## WEST SUSSEX COUNTY COUNCIL CONSULTATION

| <b>FROM:</b>                    | WSCC - Highways Authority                                                                                                                                                                                                                                                                                                                                                                                                                                    |
| <b>LOCATION:</b>                | Land West of Pagham Road<br>Pagham                                                                                                                                                                                                                                                                                                                                                                                                                           |
| <b>SUBJECT:</b>                 | P/178/21/OUT<br><br>Outline application with all matters reserved (except access) for the construction of up to 106 new homes, formation of access onto Pa

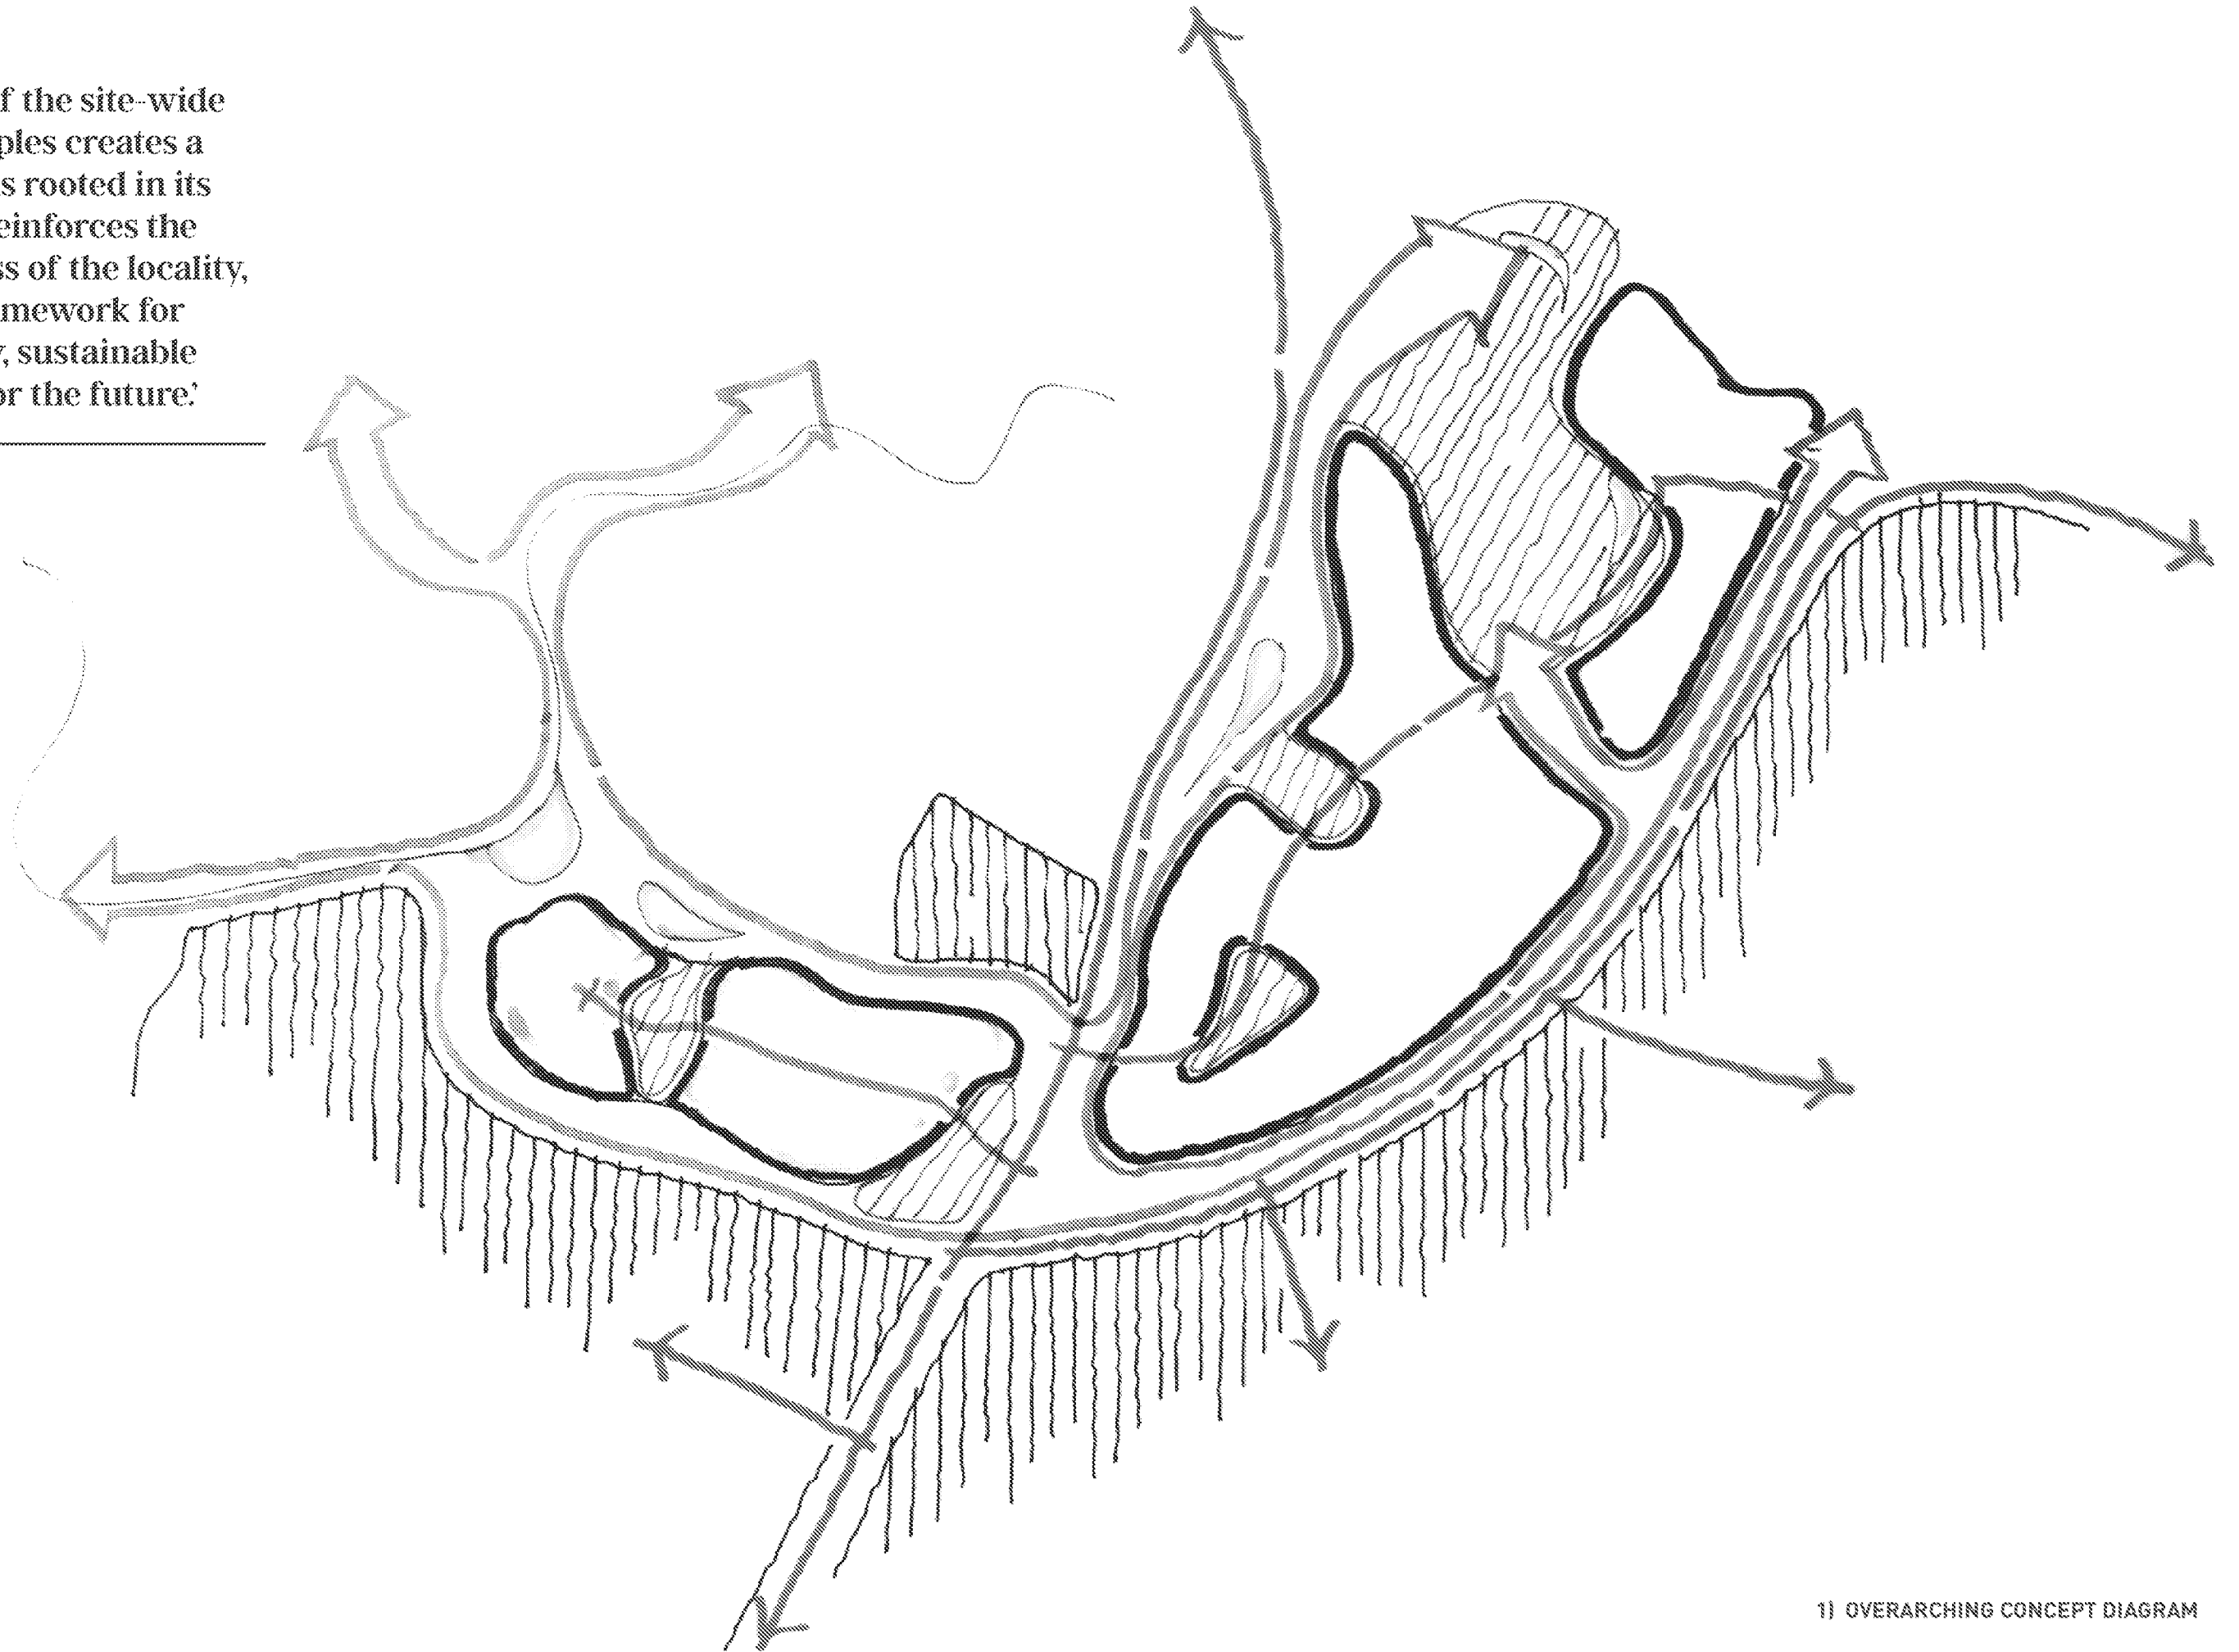
20.The application seeks permission for outline consent with only matters of access to be approved at this stage. The illustrative layout is consequently noted but has not been reviewed in detail at this stage. The only aspect raised would be the number of plugs, which results in quite a number of no through roads. As part of any detailed layout, the plugs should be removed to create through roads. Unless there's good reason, the plugs should be removed to provide a connected layout and avoid unnecessary reversing manoeuvres especially for servicing vehicles.
